Planning Act 2008 (as amended) – Section 51

Application by Gate Burton Energy Park Ltd for an Order Granting Development Consent for the Gate Burton Energy Park.

Advice following issue of decision to accept the application for examination

Format : A1  
Scale: 1:2500

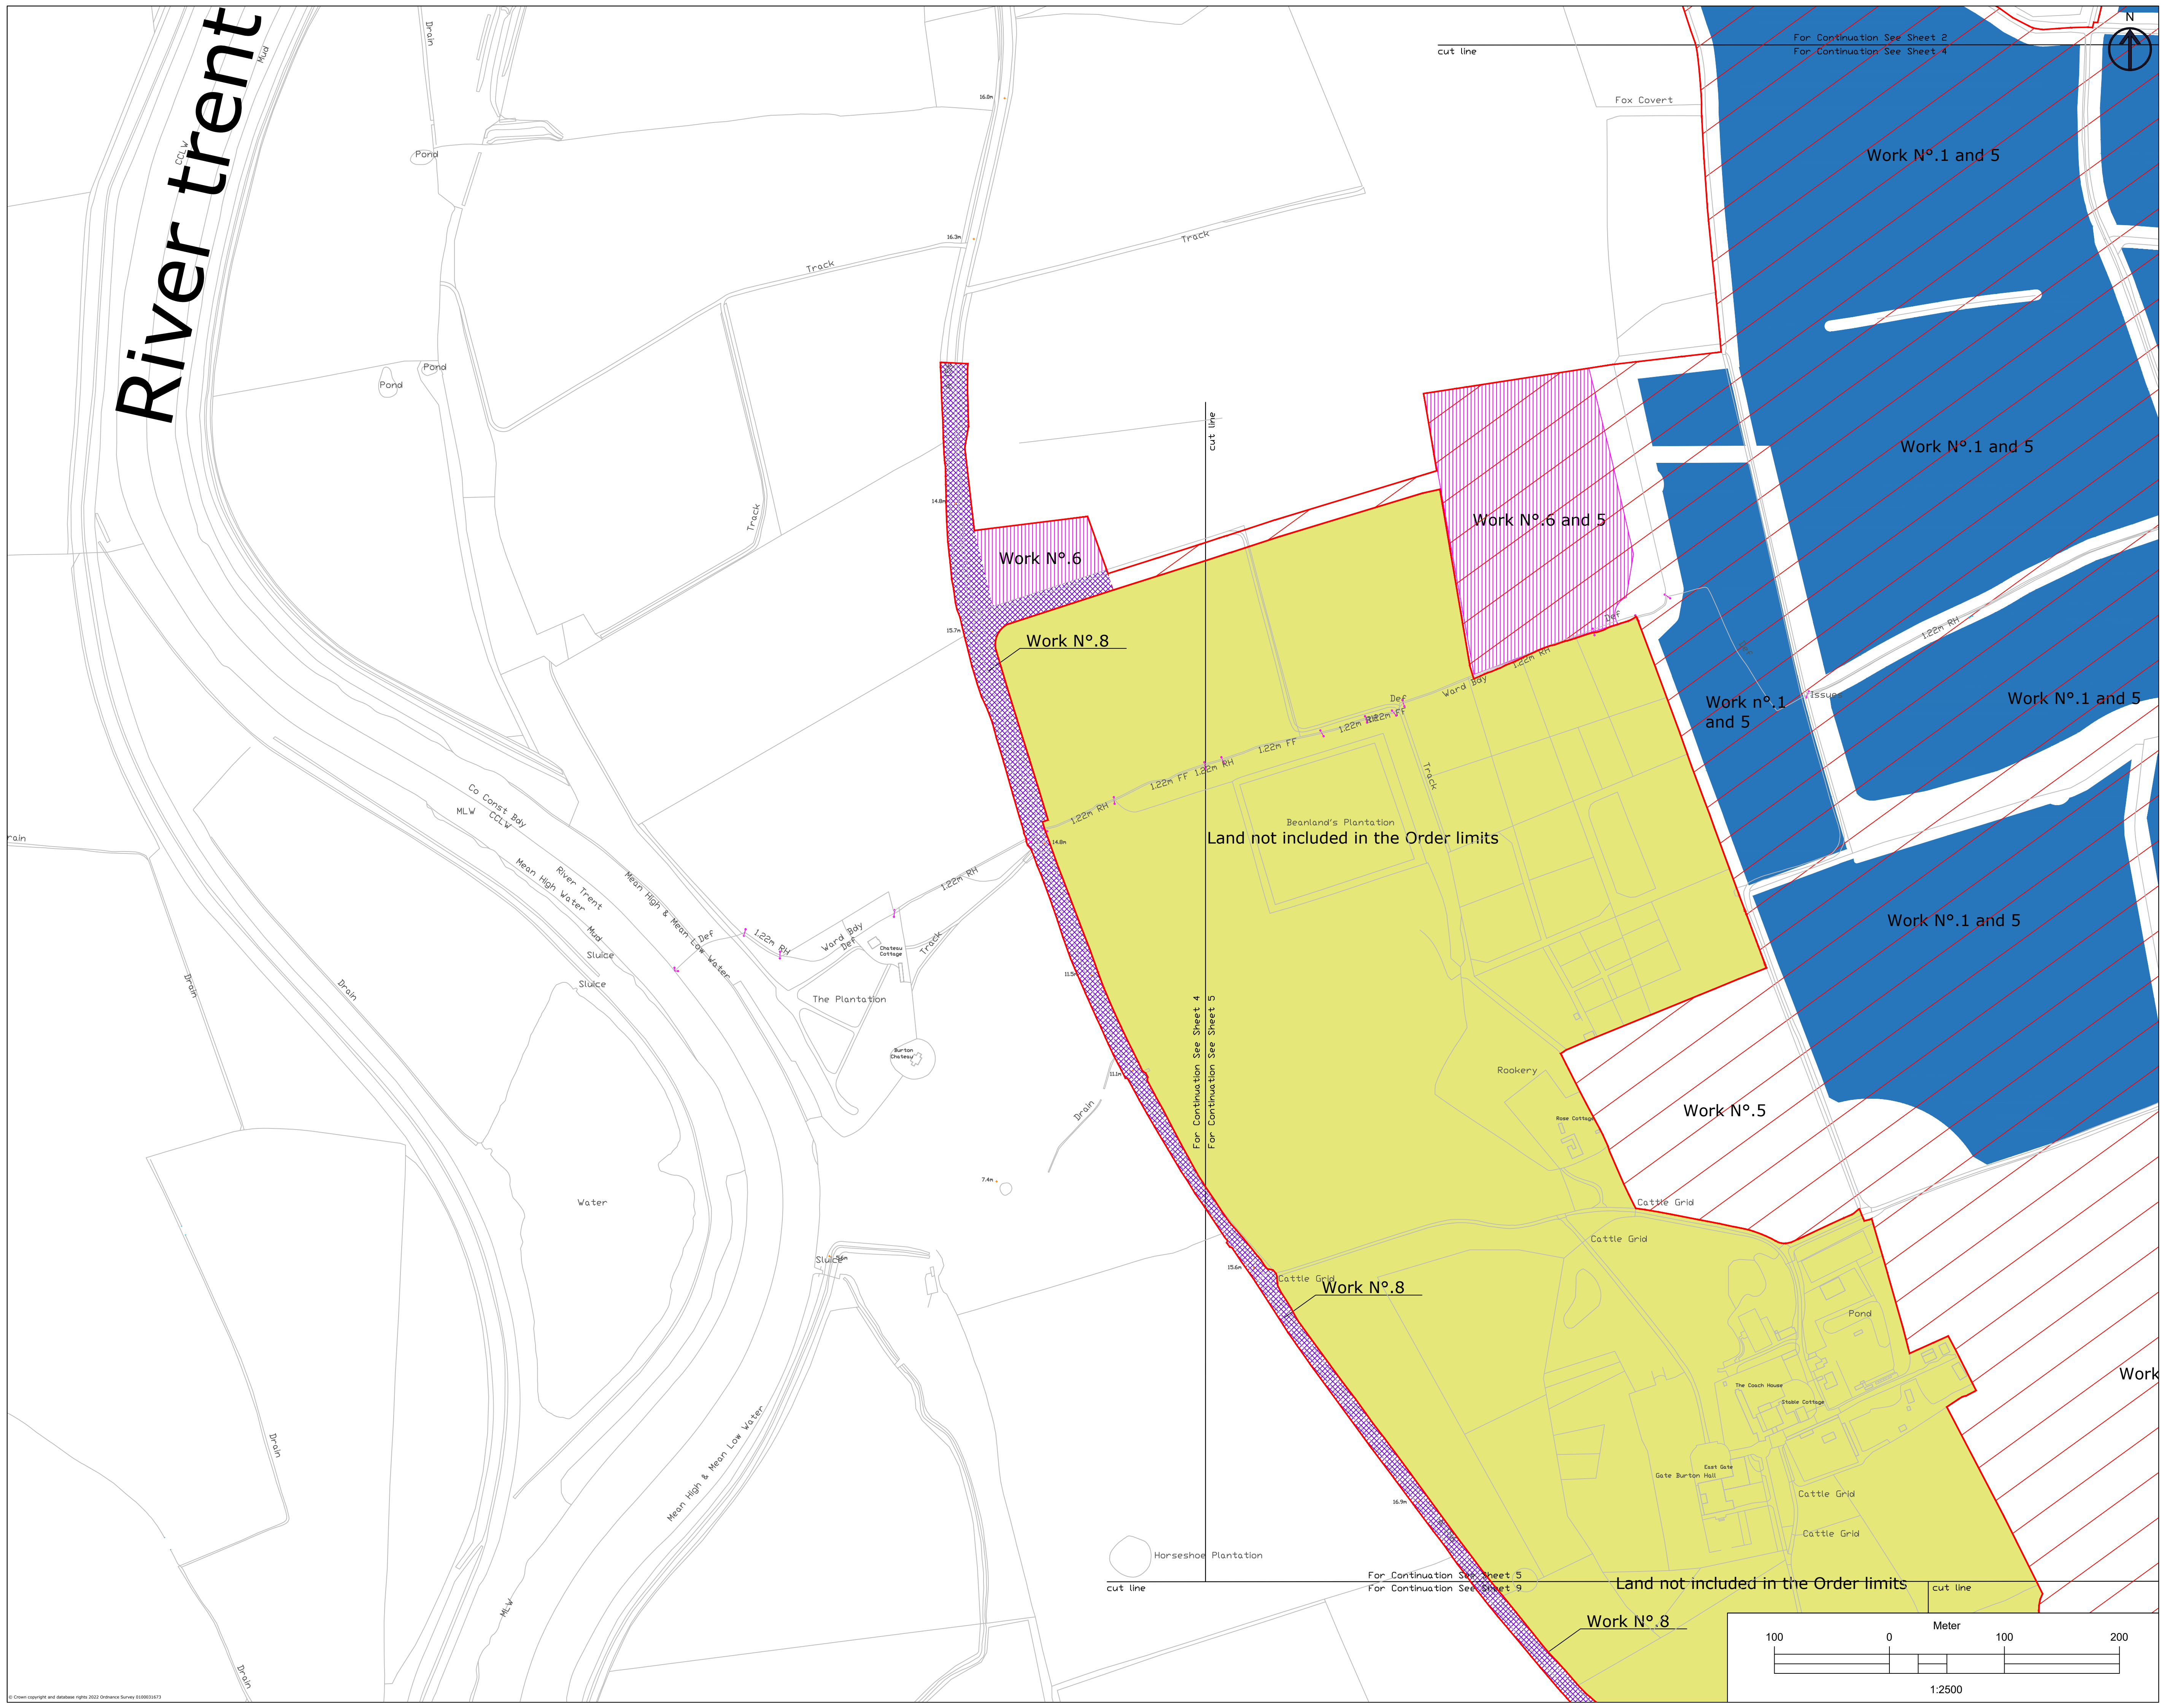
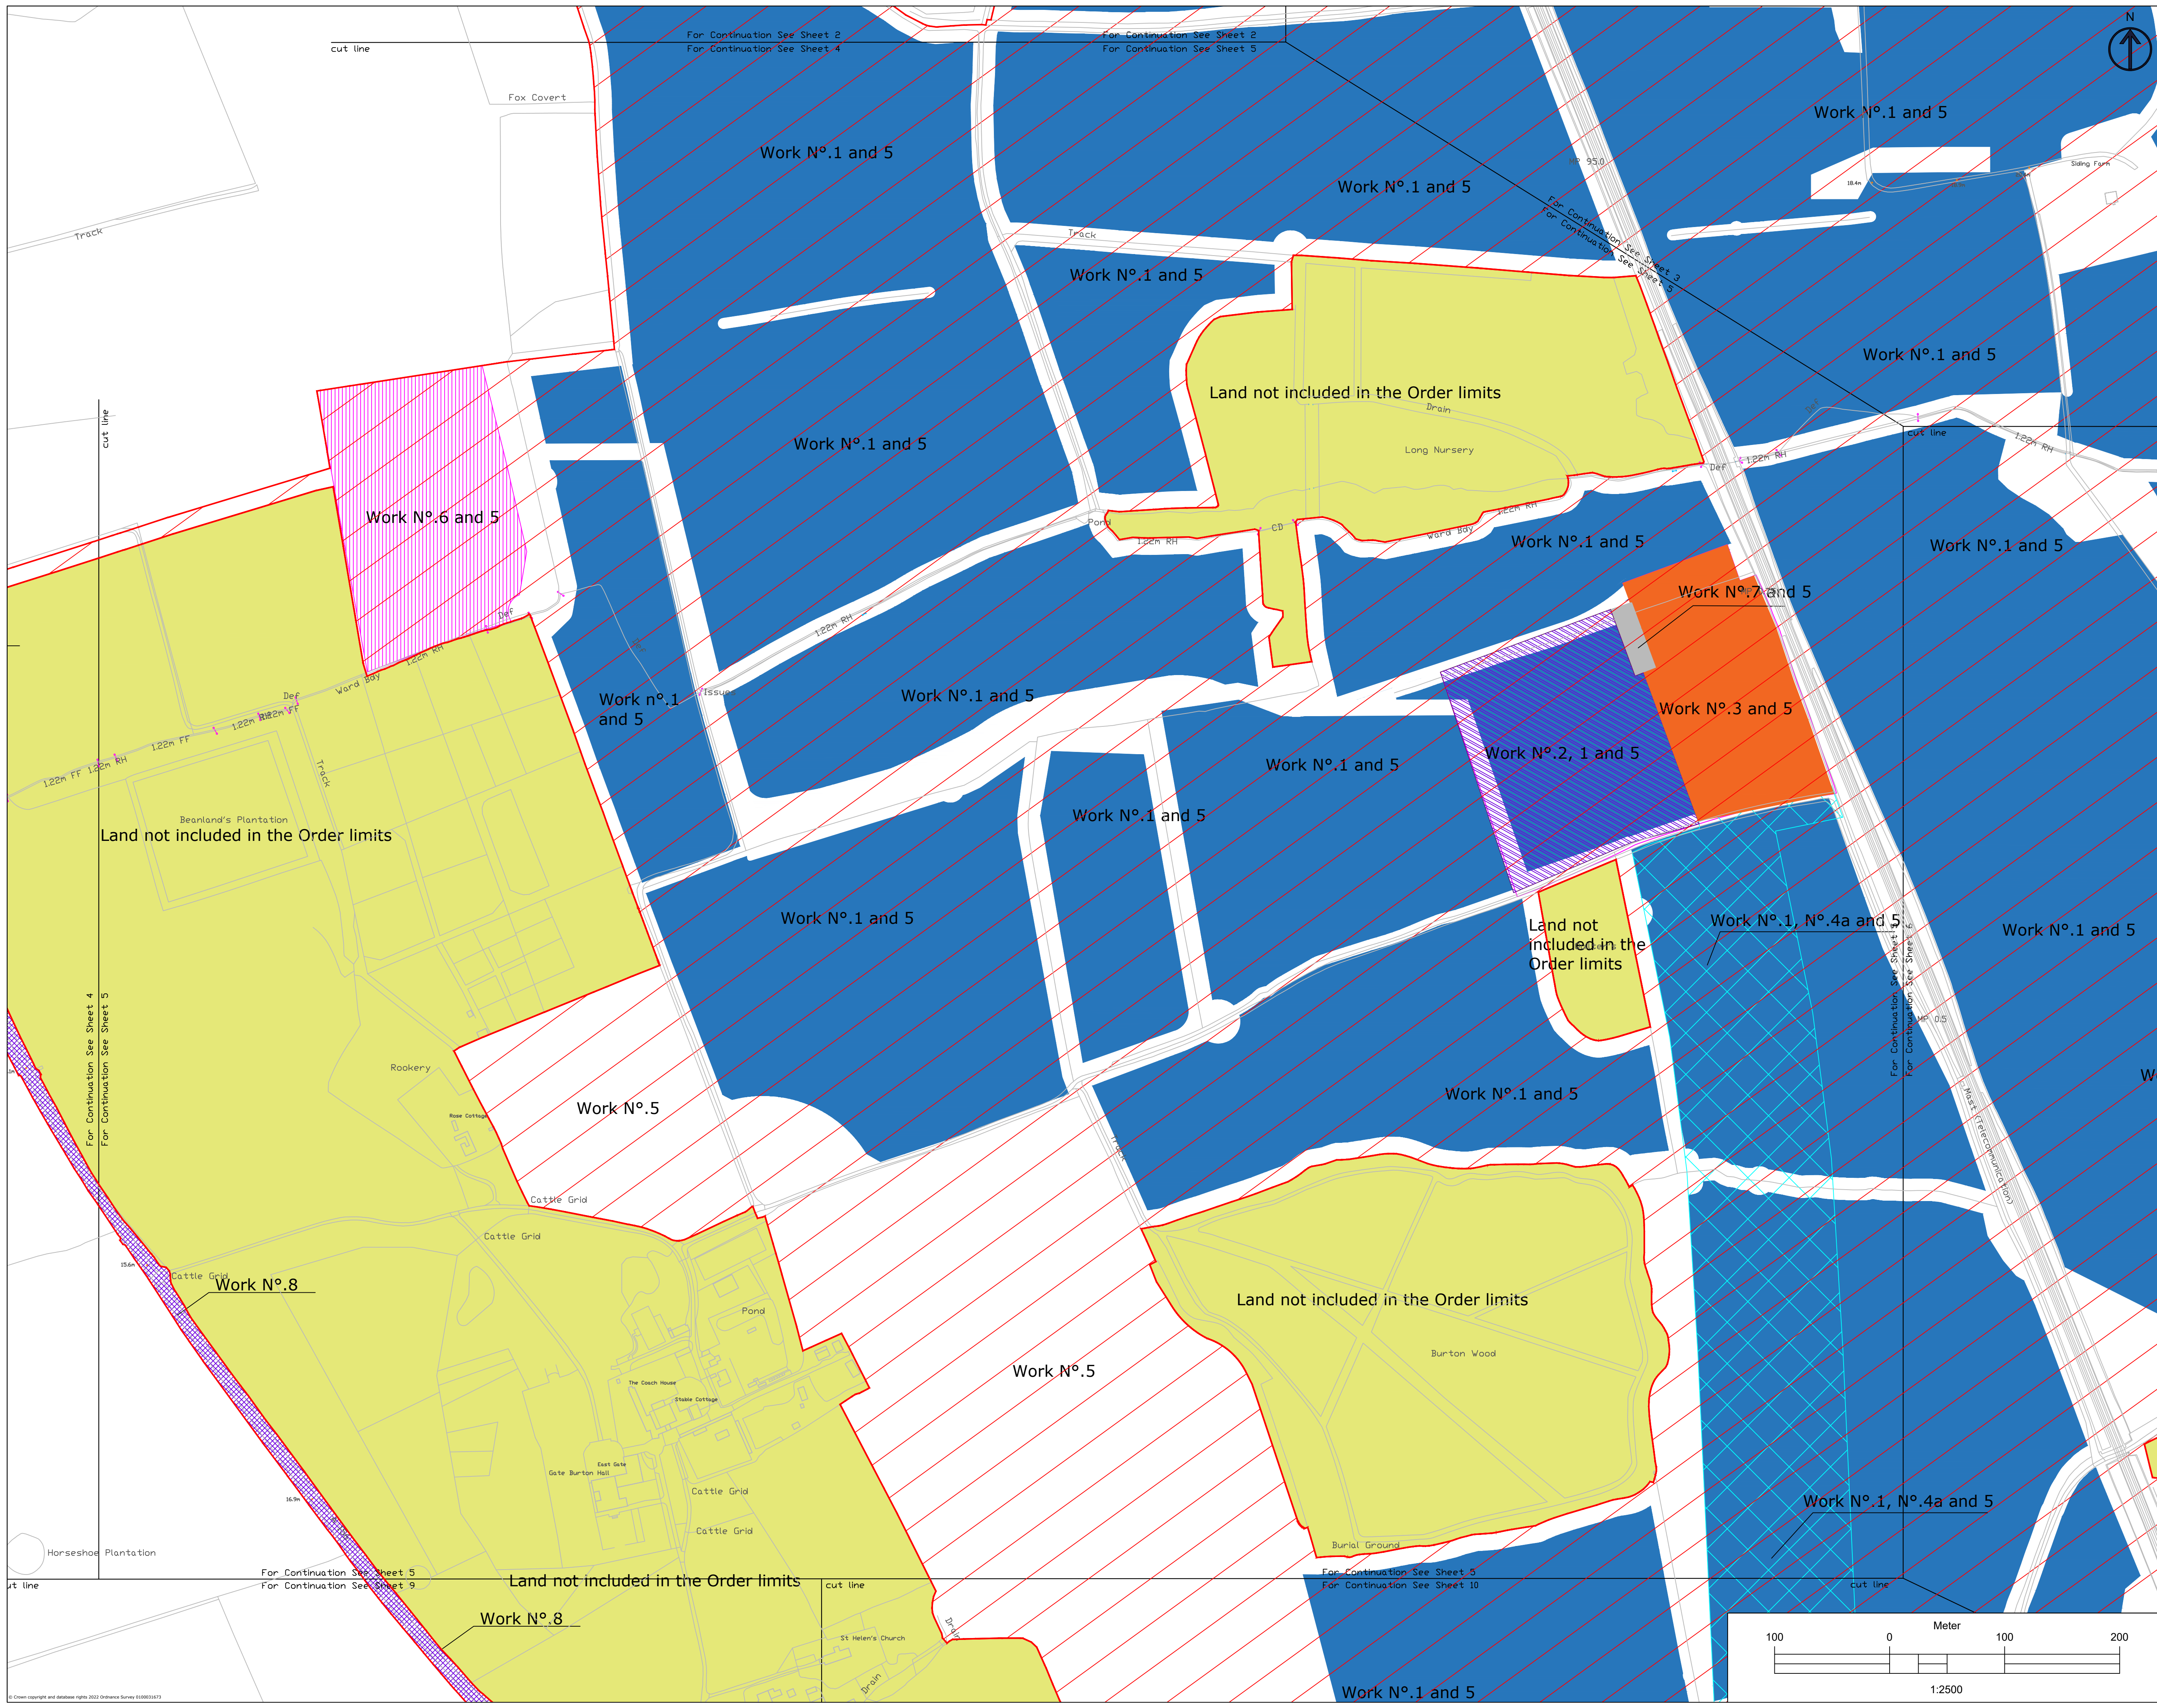
The Applicant is advised to conduct a consistency check between the Legend and the plan. For example, alphanumeric annotation is used on Works Plan but is not included in the Legend, and the colours used in the Legend do not collate well to the plan, for example, the yellow in the legend is much brighter to that used on the plan.
